Recommendation Report for Planning Permission for Works or Extension to a Dwelling

REF NO: M/97/20/HH

LOCATION: 10 Lodge Close
Ancton
Middleton-On-Sea
PO22 6NF

PROPOSAL: Conversion of existing garage to habitable room and lifting of flat to accommodate headroom.

Proposed Front (East) Elevation (Scale 1:100)

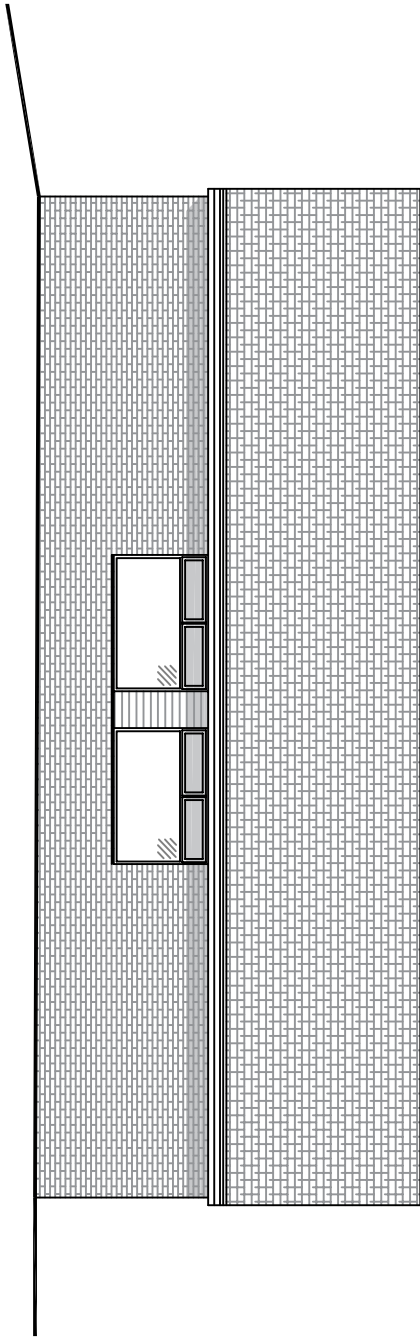
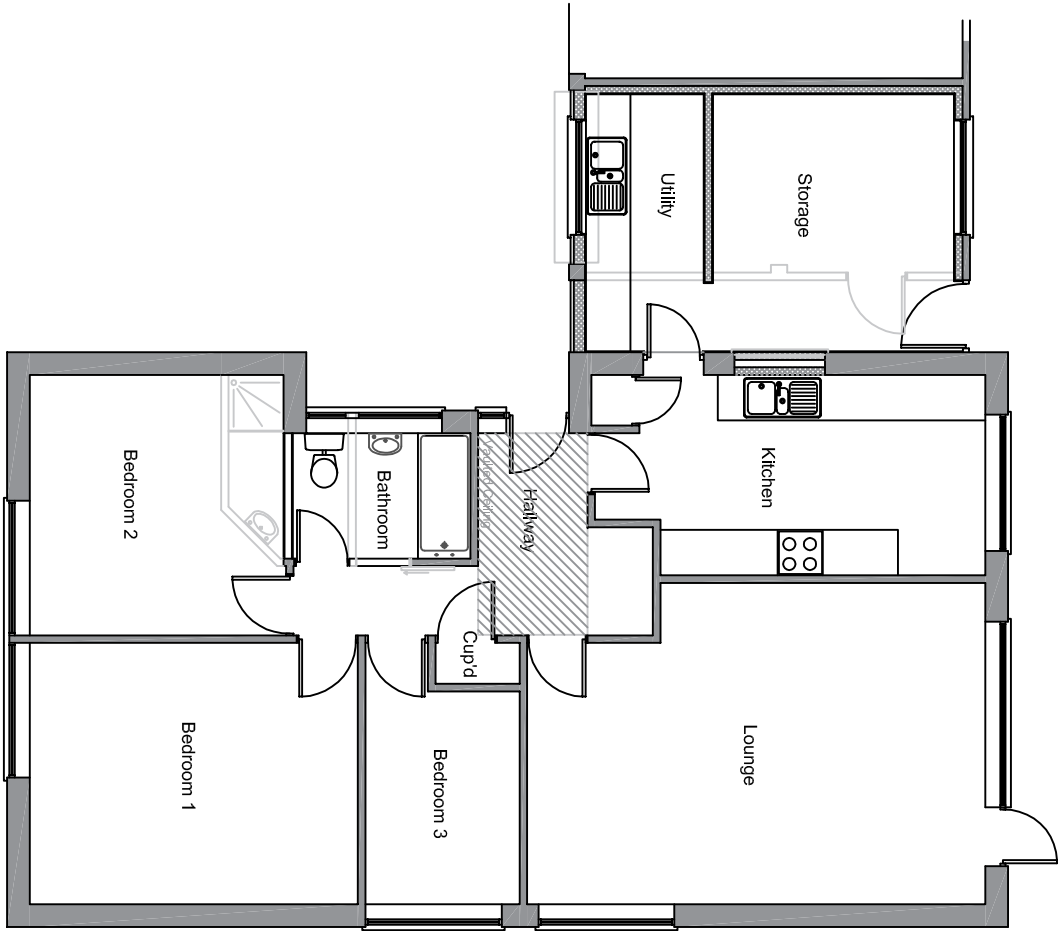
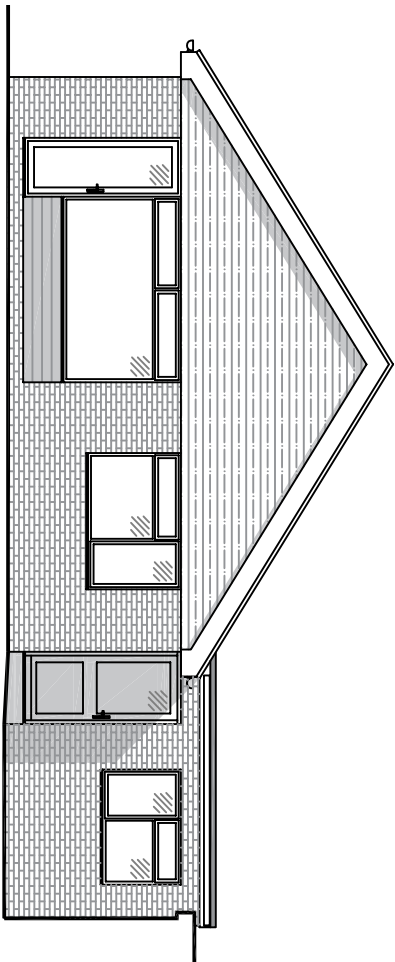
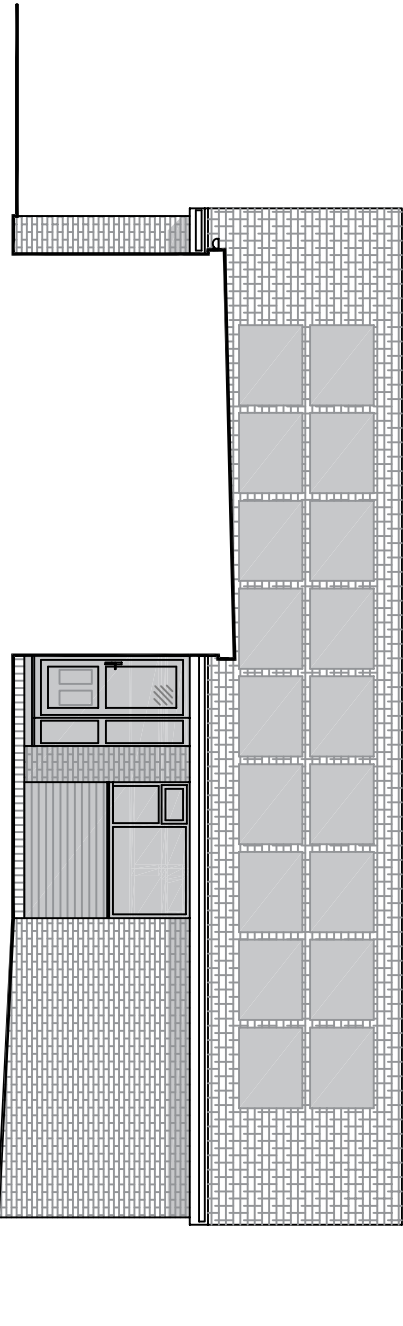
The proposed development is considered to have an acceptable impact upon the character of the area. The majority of the alterations are internal, and the main visual change will be that the roof height will increase approximately 0.45m and the aspect of the building that faces the street scene will have alterations to its fenestration. This is because the existing garage door will be bricked up, and replaced with a window. Whilst this would be a unique feature within locality, however, it is not considered so significant a change that the application should be refused.

The proposed development incorporates no physical changes that have a significantly unacceptable overshadowing, overlooking or overbearing impact on occupiers of adjacent dwellings. This is due to the modest scale of the height increase and the aspect of the development site. Therefore, the proposed development is considered to be in accordance with D DM1(3) and D DM4(c) of the Arun Local Plan.
